CITY OF ALBUQUERQUE

January 25, 2017

Re: Arroyo Vista Apartments
4201 Bryn Mawr Dr. NE
Traffic Circulation Layout
Architect's Stamp 11-04-16 (G16-D0153)

sheet no: TCLI

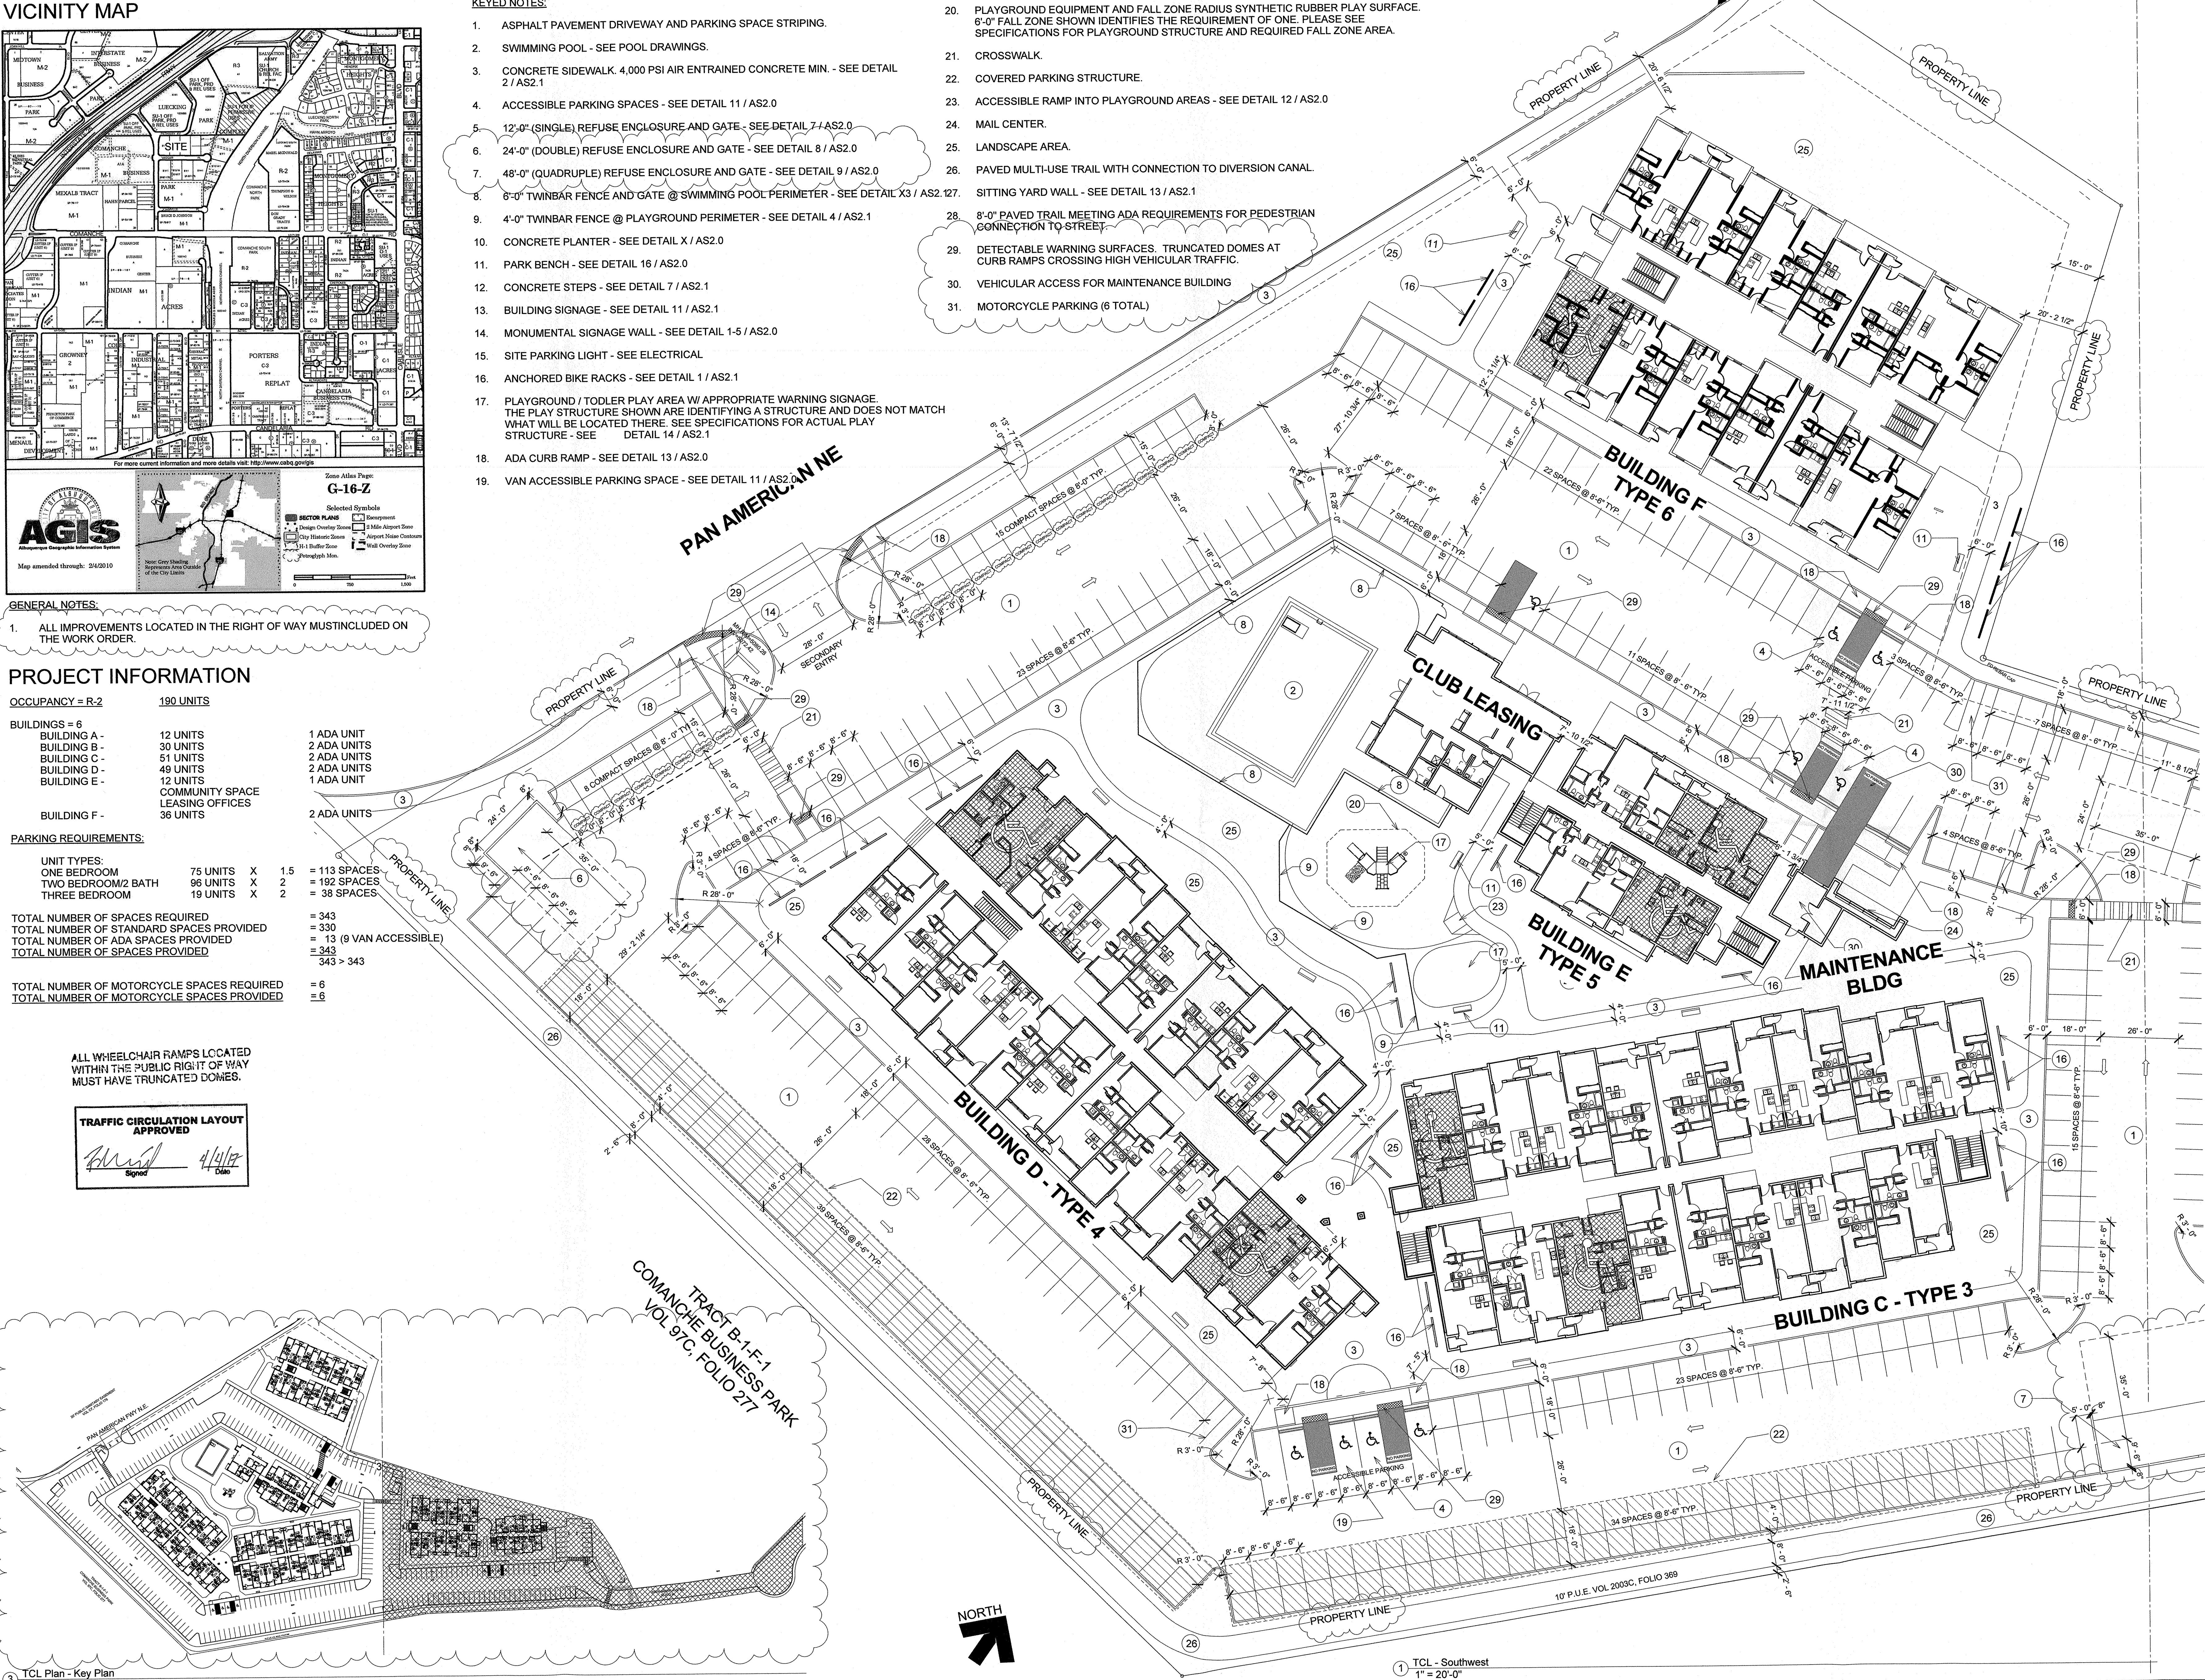
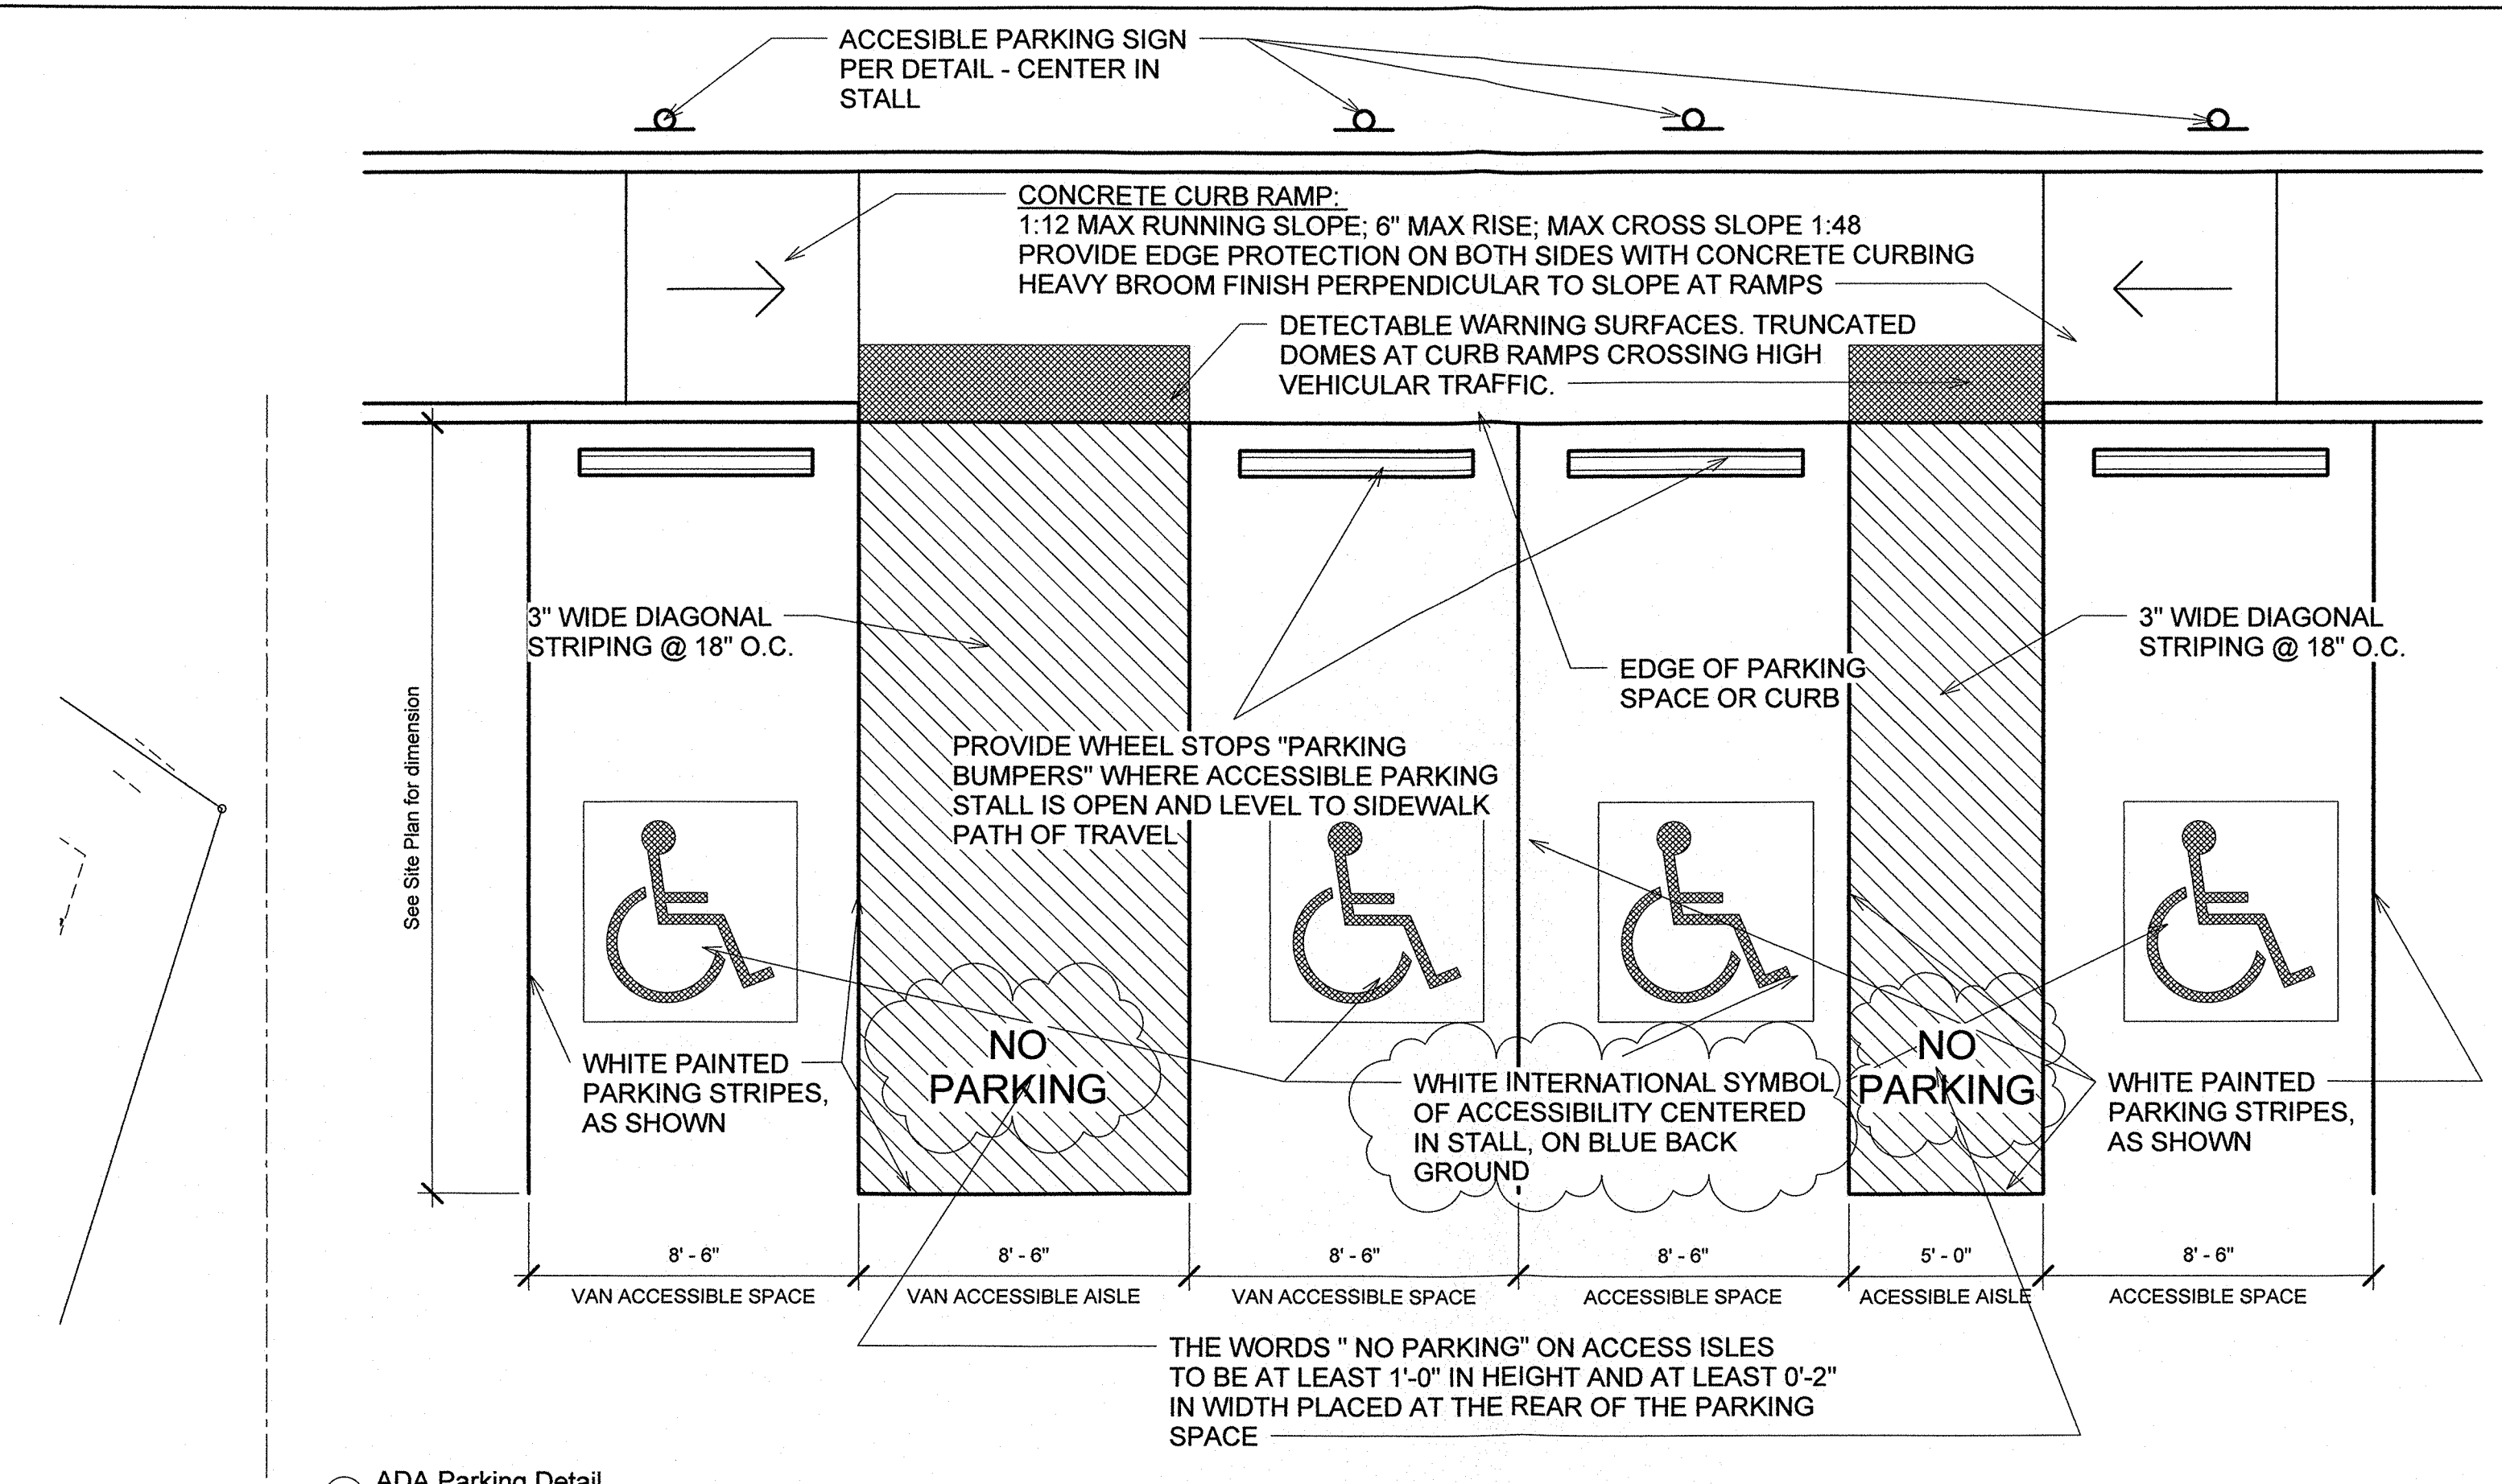
2. Identify all existing access easements and rights of way width dimensions. Please provide an exhibit for all accesses to site.
3. Identify the right of way width, medians, curb cuts, and street widths on Pan American NE and Bryn Mawr Dr. NE. Correct the road name Pan American Fwy NE to Pan American NE.

4. Clarify existing property lines and proposed property lines. Also include any easements existing or proposed.
5. Use match lines on plans to show continuation on second page.

6. Label the compact parking spaces by placing the words "**COMPACT**" on the pavement of each space.
7. The ADA access aisles shall have the words "**NO PARKING**" in capital letters, each of which shall be at least one foot high and at least two inches wide, placed at the rear of the parking space so as to be close to where an adjacent vehicle's rear tire would be placed. (66-1-4.1.B NMSA 1978)

8. The ADA parking space has a clearly visible, blue, International Symbol of Accessibility painted on the pavement at rear of the space (66-1-4.1.E NMSA 1978) or MUTCD recommends a white symbol on a blue background.

9. Please dimension all pedestrian path ways and crosswalks. Some dimensions are not shown. Add ADA note referring to cross and running slopes for pedestrian paths. The site looks to have large grade changes.

10. Detectable warning surfaces, truncated domes should be used at curb ramps crossing vehicular traffic. Please provide details referenced in TCL keyed notes.

11. Clarify connection to Maintenance building between the handicap parking.

12. Dimension the drive aisle width off of Bryn Mawr.
13. List radii for all curves shown; for passenger vehicles, the minimum end island radius for passenger vehicles is 15 ft. Radius for delivery trucks, fire trucks, etc. is 25 ft. or larger. The secondary entrance could use a larger radius than 12 feet.

14. A 5 ft. keyway is required for dead-end parking aisles. Please add dimensions on the TCL.
15. Per the zoning code, a 6 ft. wide ADA accessible pedestrian pathway is required from the public sidewalk to the building entrances. Please clearly show this pathway and provide details.

16. Per DPM, a 6 ft. wide ADA accessible pedestrian pathway is required from the HC parking stall access aisles to the building entrances. Please clearly show this pathway and provide details.
